From: Paul Hague [REDACTED]
Sent: 13 November 2015 12:22
To: Anita Gardner
[REDACTED]

Subject: WA/60/15/HH - First Floor Extension 6 Nash Way, Walberton*

## Proposed Elevations

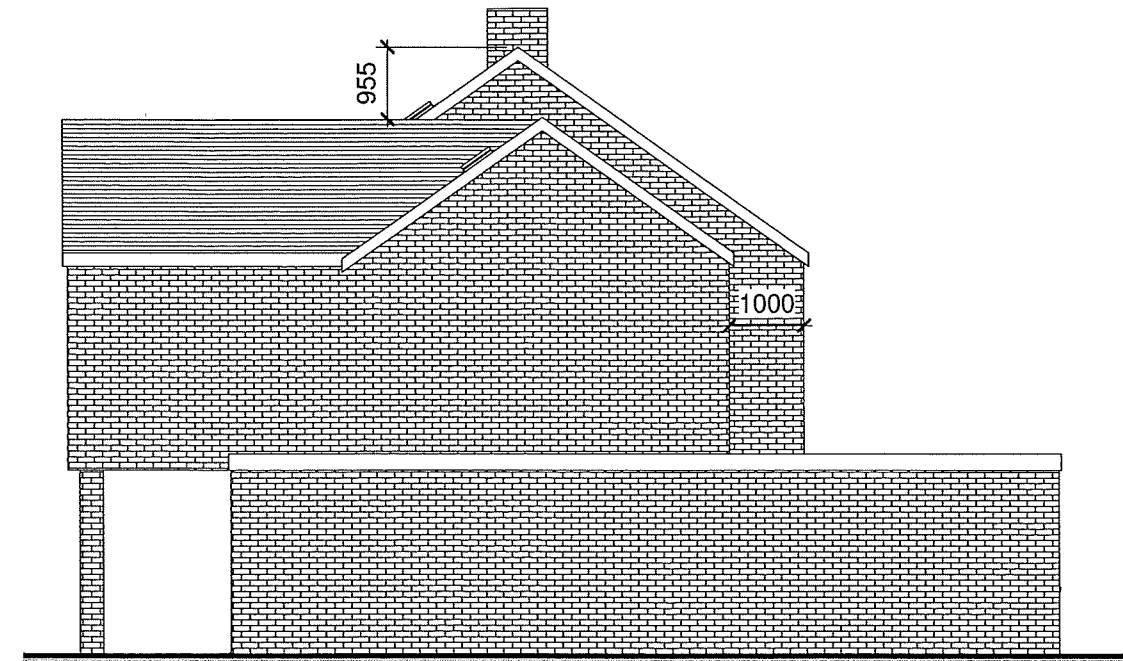
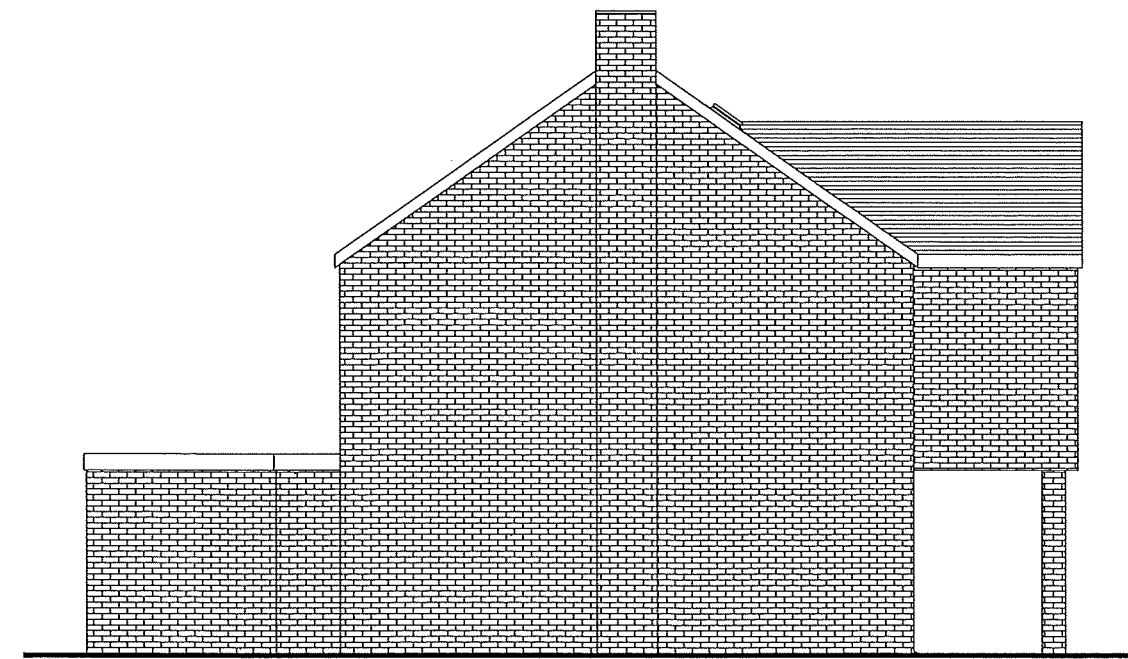
The amendment does not reduce our objection since it does not address the problem of taking light out from our windows.

Any projection to the rear of the property, and we note it would appear a balcony would be included, would take away the privacy and seclusion that we currently enjoy.
